From: Laura Gibbons
Sent: 09 May 2018 15:19
To: Planning.Responses
Subject: RE: Planning Consultation on AL/43/18/DOC

APPLICATION **AL/43/18/DOC**
NO:

Description of Works: Approval of details reserved by condition imposed under
AL/139/16/HH relating to condition 3-surface water drainage.

SITE PLAN 1:200 @ A3

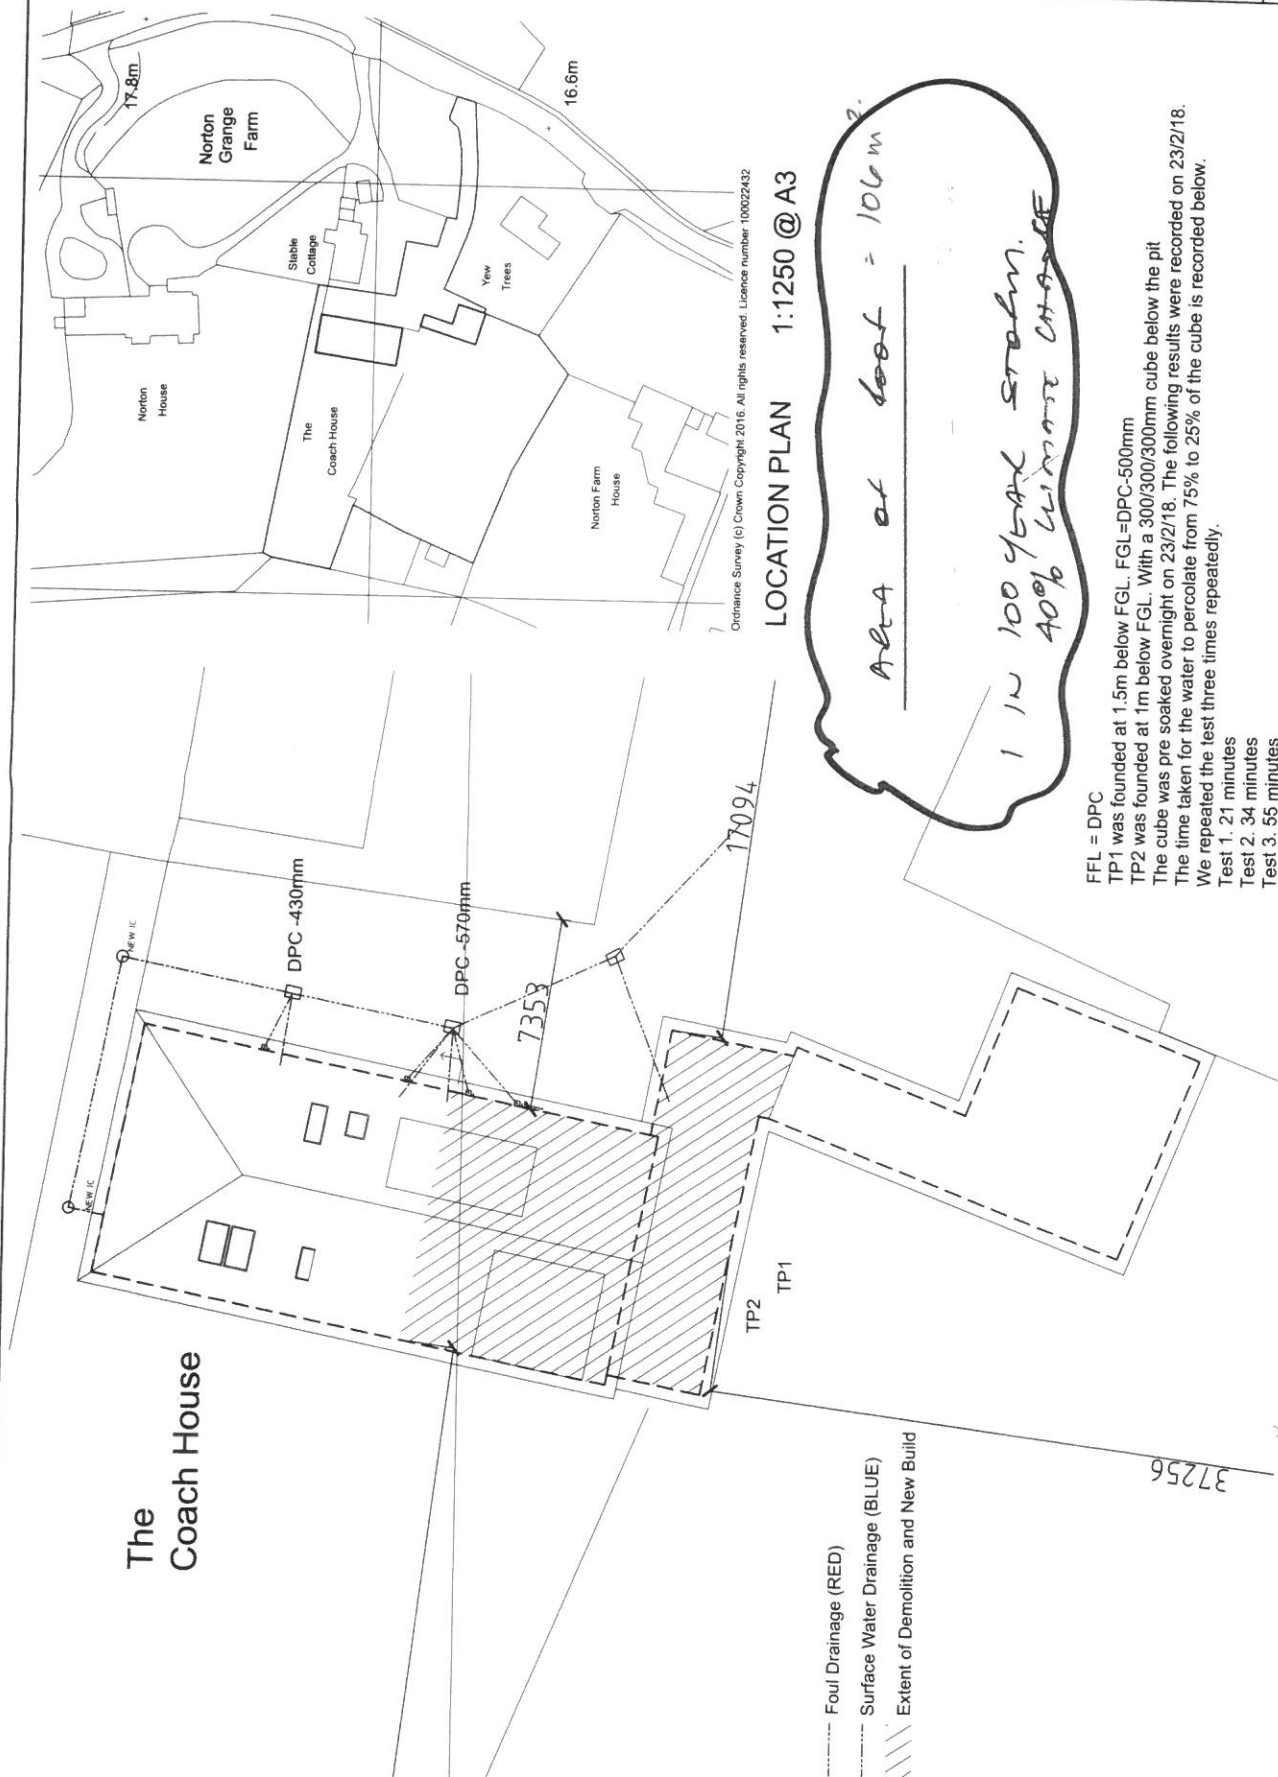
- * Please provide details of the winter groundwater monitoring results.
- * Please provide invert levels of all pipes.
